Mountain View Electric Association, Inc. (MVEA) has these comments about the following:

**Project Name: 18884 & 19004 Hilltop Pines Plat Amendment**

**Project Number: SF 1916**

as replatted:

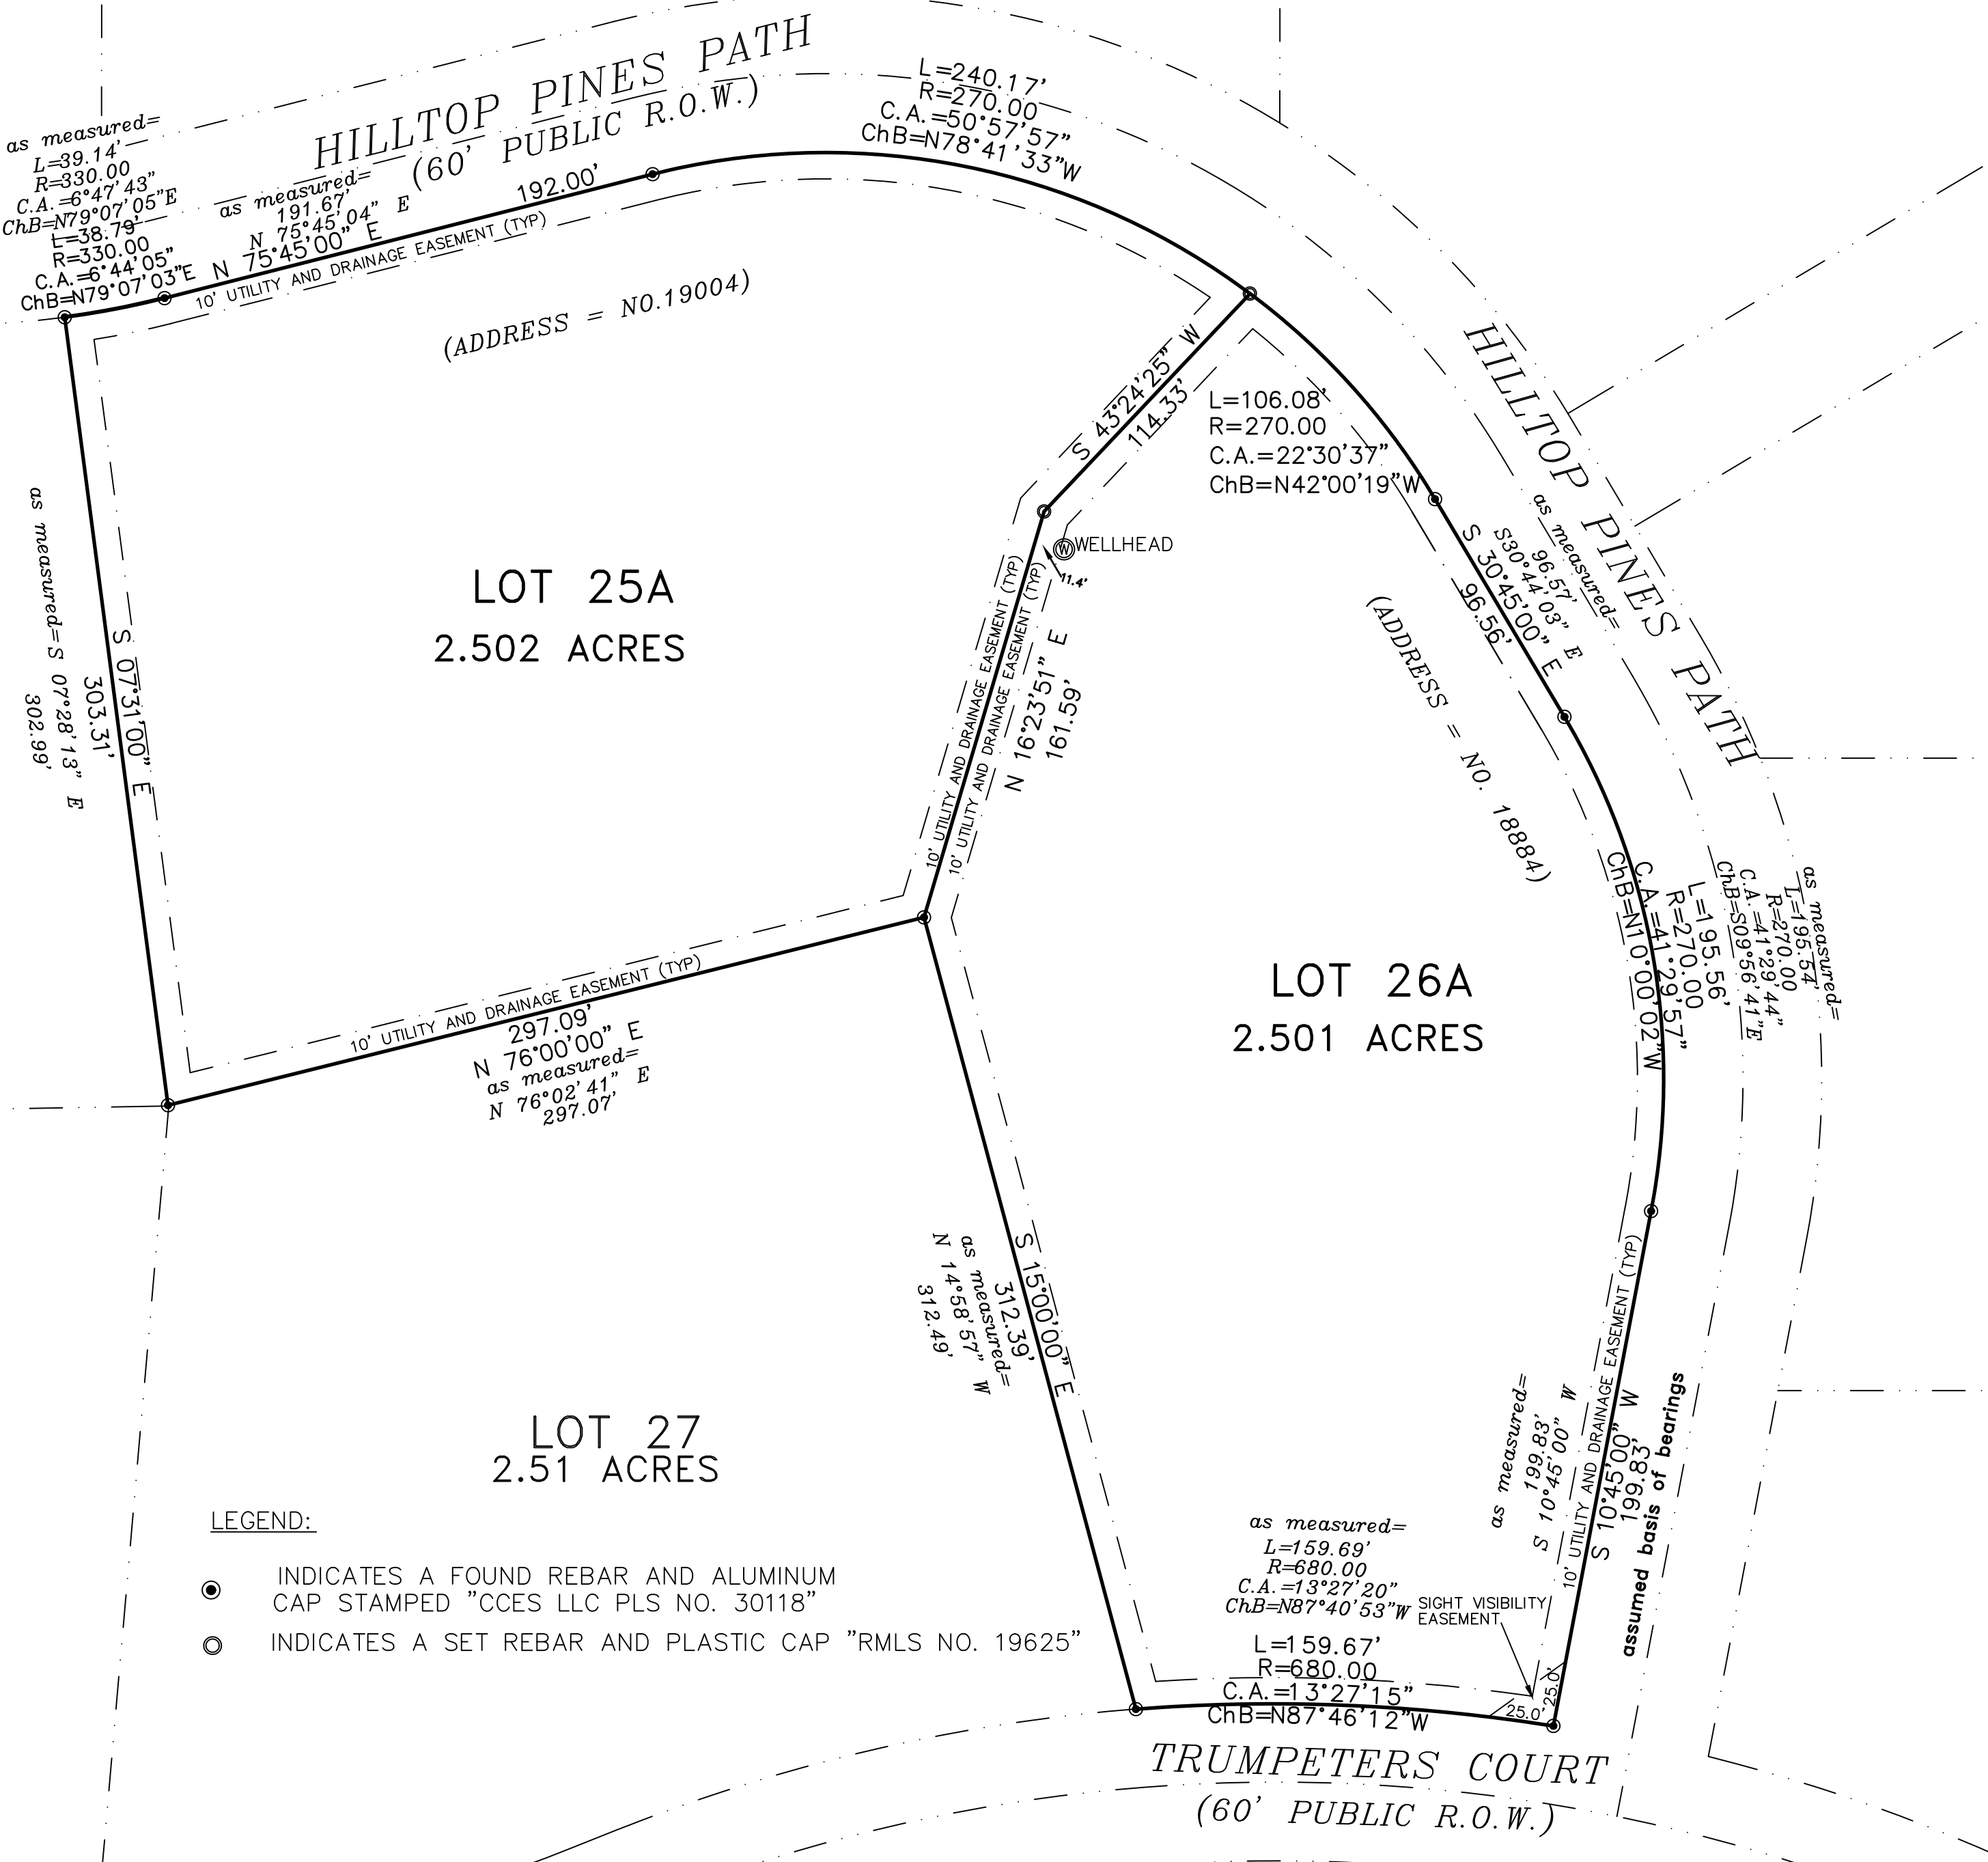
MVEA request the original utility easements be reinstated of ten (10) foot rear, side and front lot line for the 2 residential lots being redesigned. If there is any removal or relocation of facilities it will be at the expense of the applicant and a review of easements will be required.
